PLANNING APPLICATION
REF BE/17/18/PL
37 NORBREN AVENUE
NORTH BERSTED
BOGNOR REGIS
WEST SUSSEX
PO21 5HE

MRS MARY JACKSON
35 NORBREN AVENUE
NORTH BERSTED
BOGNOR REGIS
WEST SUSSEX
PO21 5HE

12. 3. 18

Farhad Aarabi	
PROJECT	Proposed Bungalow 37 Norbren Avenue, Bognor Regis
TITLE	Proposed Elevations
CLIENT	Mr & Mrs Clarke
SCALE	1: 100
DRAWING NO.	906-02
DATE	16/09/2017
rev.

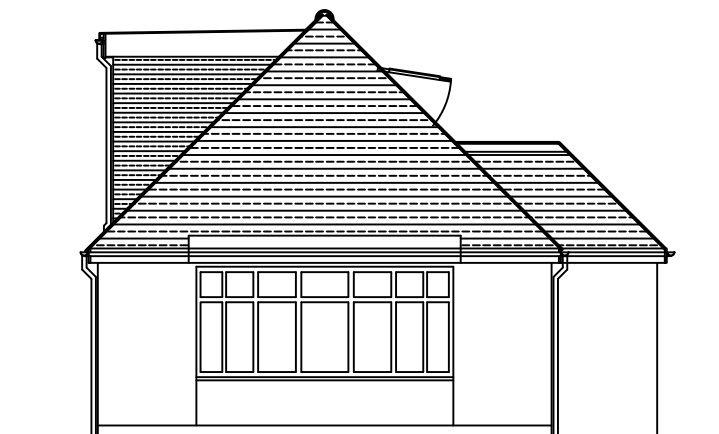
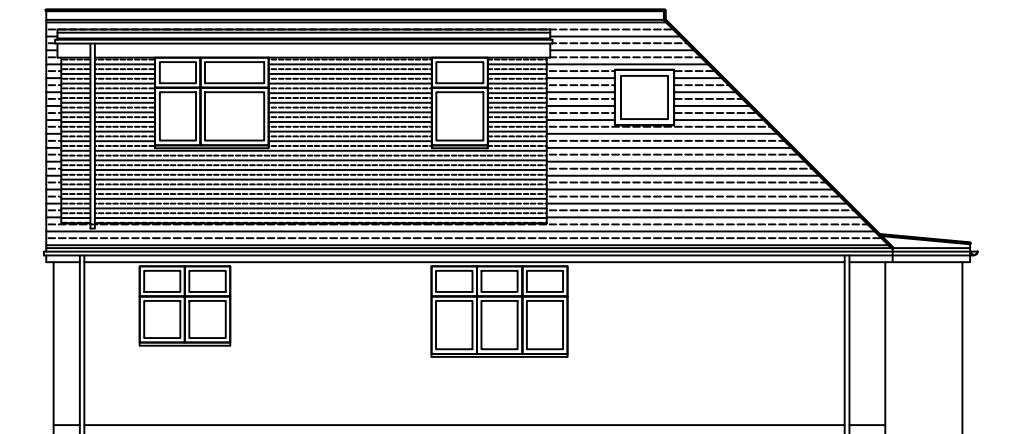
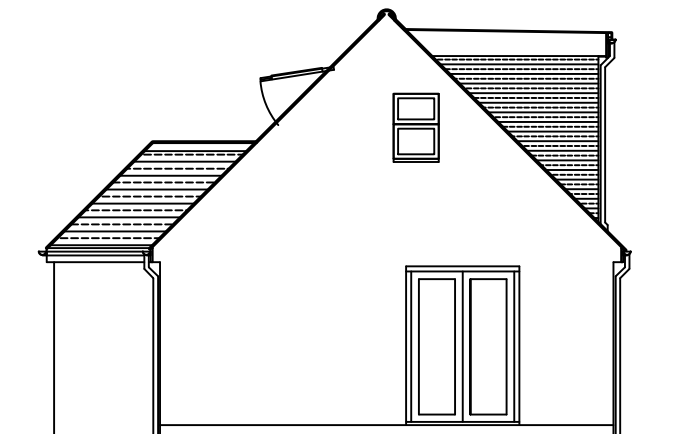
- ④ THE FINAL OBJECTION WE WOULD RAISE IS RELATED TO THE DESIGN. THE APPLICATION MENTIONS "BRICKWORK" TO BE FORMED IN ORDER TO SUIT THE EXISTING BUILDING. ALL OF THE NEIGHBOURING HOUSES WERE BUILT IN THE 1930'S PERIOD, AND AS SUCH MANY OF THE MATERIALS USED ARE NOT SIMPLY OBTAINABLE. DOES THE APPLICANT KNOW OF A SOURCE OF MATERIALS TO MATCH THE EXISTING HOUSES. IT IS NOT AS SIMPLE AS WEATHERING NEW BRICKS. BRICKS WILL HAVE TO BE SOURCED FROM A RECLAMATION YARD. HAVE SAMPLES BEEN PROVIDED TO DEMONSTRATE THIS? IF NOT WE WOULD ASK THAT THEY ARE OBTAINED FOR APPROVAL.
